CITY OF ALBUQUERQUE

January 24, 2017

RE: Starbucks at 4601 Wyoming Blvd NE
Grading and Drainage Plan
Engineer's Stamp Date 1-9-2017 (File: F19D013C)

Based upon the information provided in your submittal received 1-9-2017, the above referenced Grading and Drainage Plan cannot be approved for building permit until the following comments are addressed:

SHEET NUMBER:
C-0010

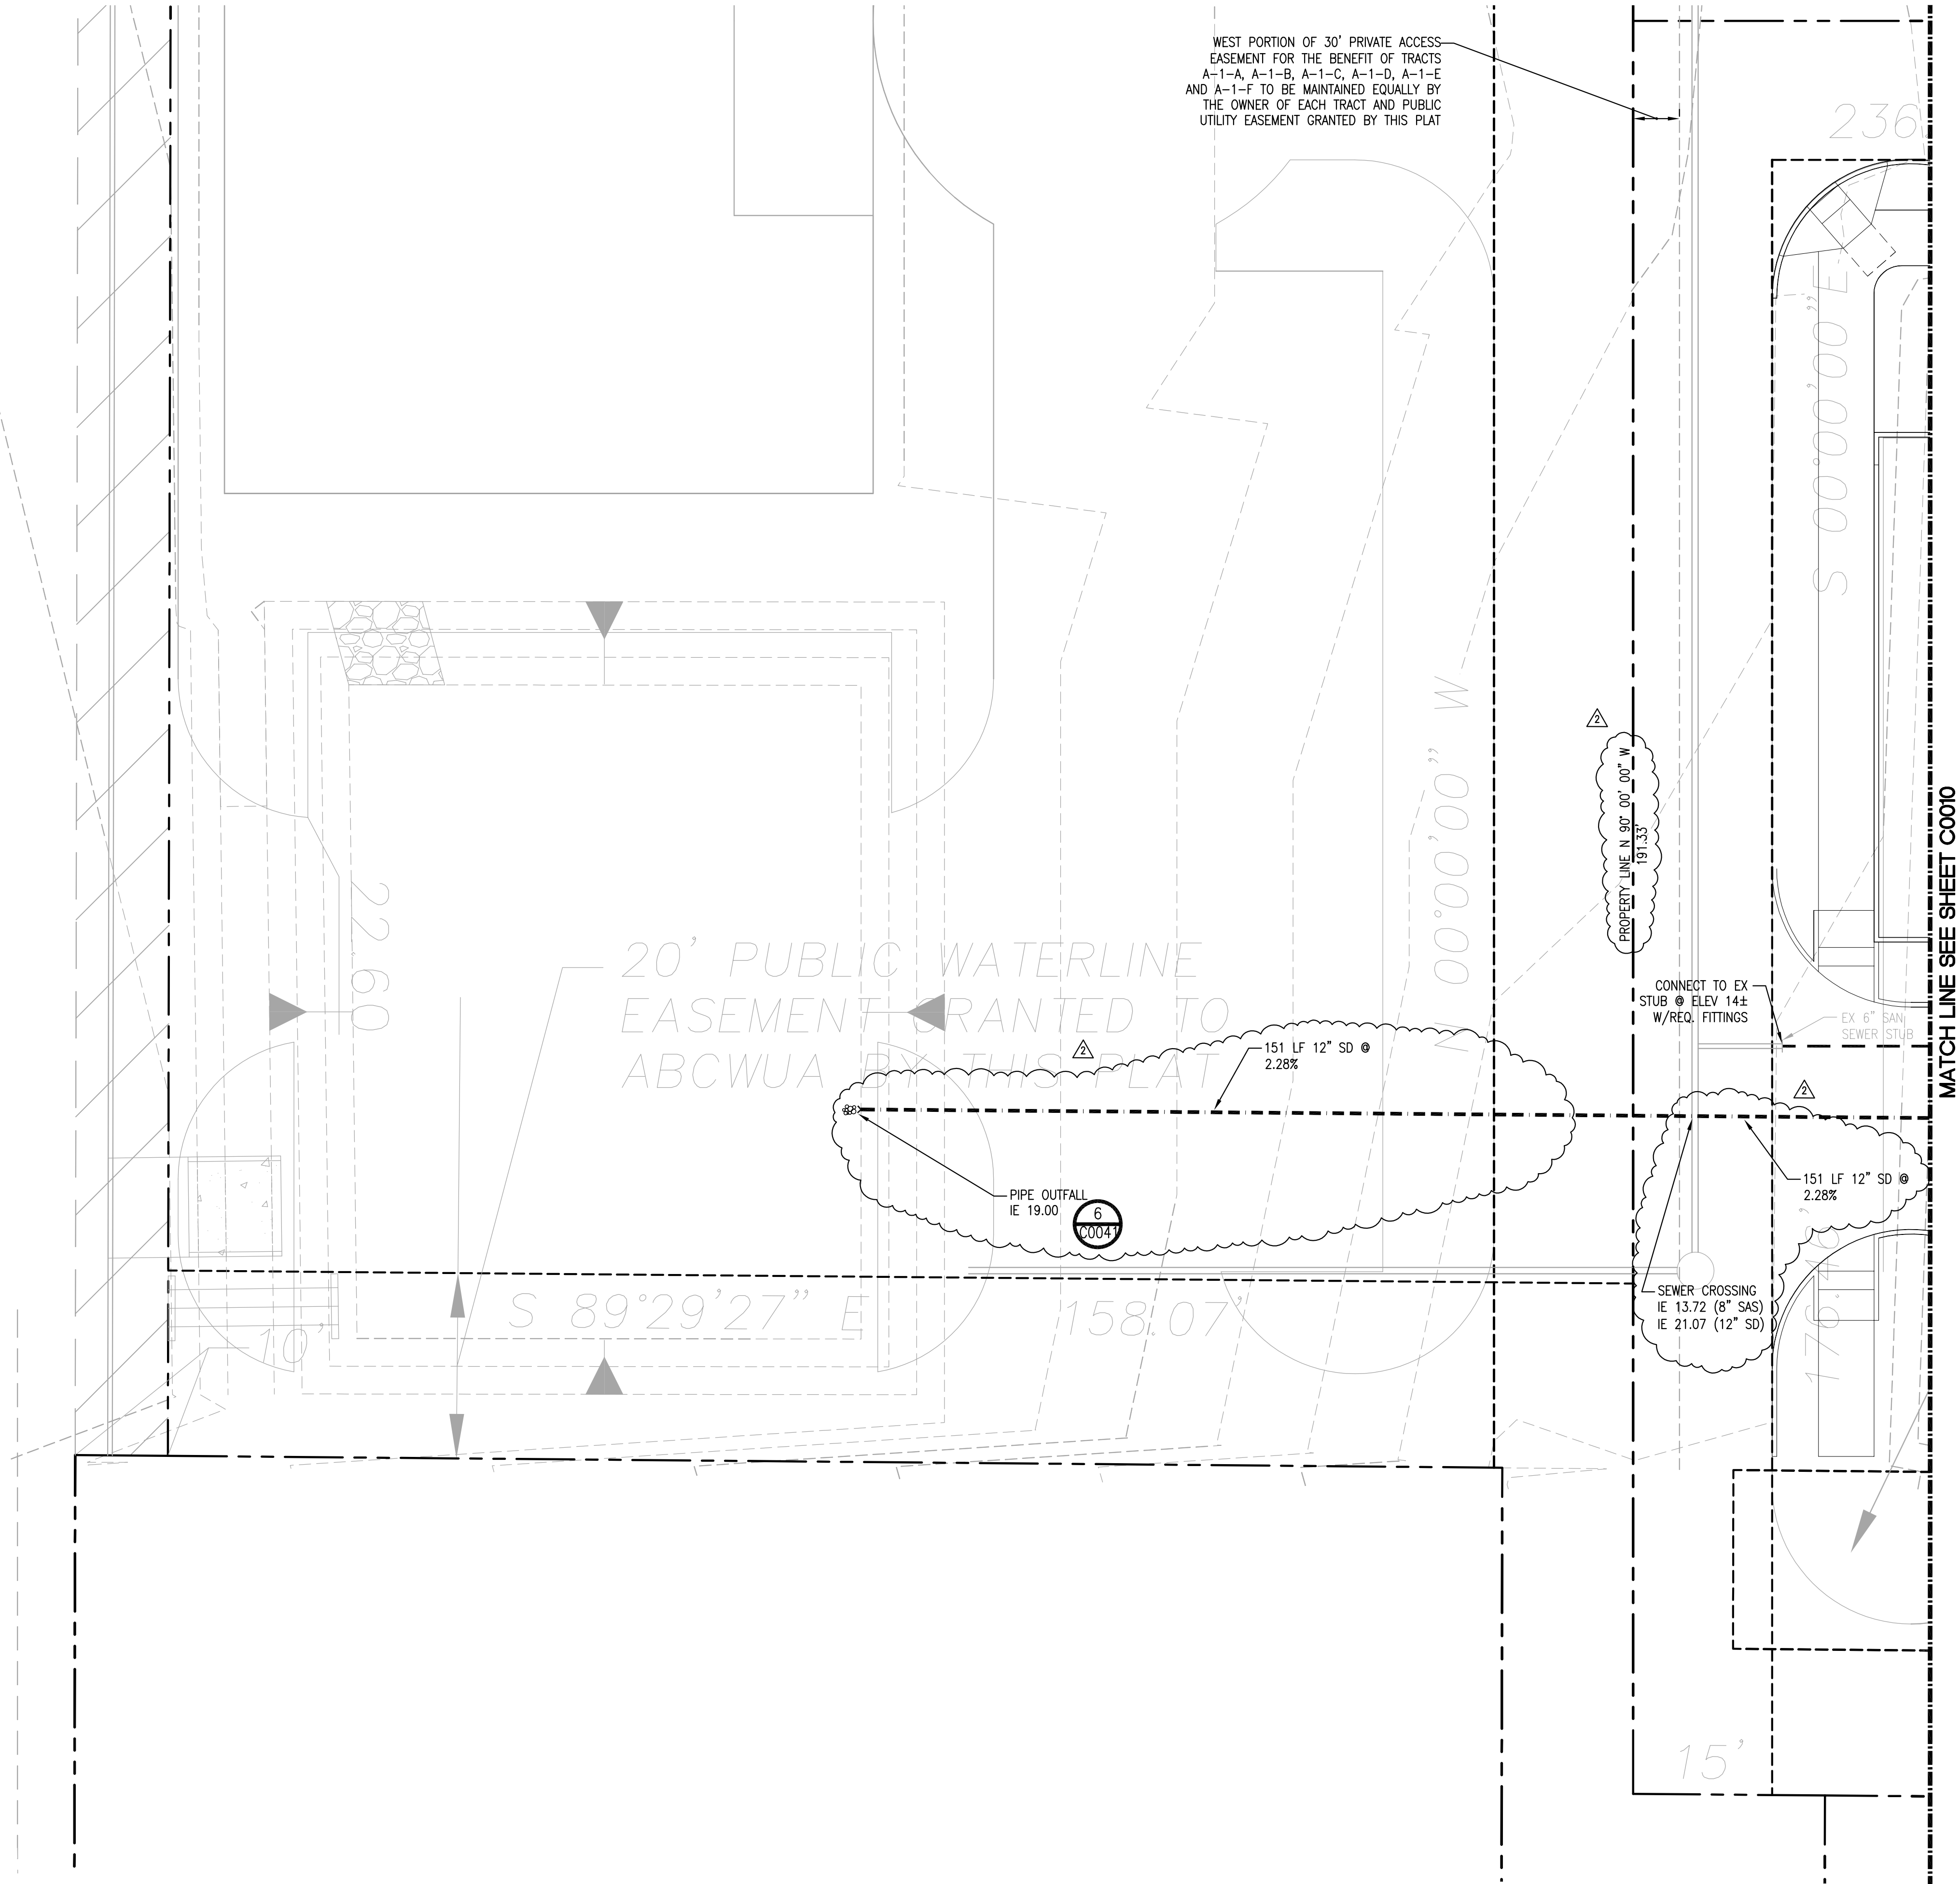
1. We recommend to use COA modified grate detail (see attached) include a copy with this plan with your next submittal.
2. Show the entire stretch of the 12 inches storm drain to the pond including grades, inverts and other utility crossing. Provide easement document across the adjacent property. Who will maintain the pond?
3. Clearly show the property line with boundary information.
4. Trash enclosure drain must drain to a grease trap then to SAS.
5. Please fix spelling of "COS STD" to "COA STD".
6. Sheet C 0001 was not printed.
7. Erosion and sediment control plan must be approved prior to building permit approval.
8. Provide inverts for the 4 feet Dia. CMP.
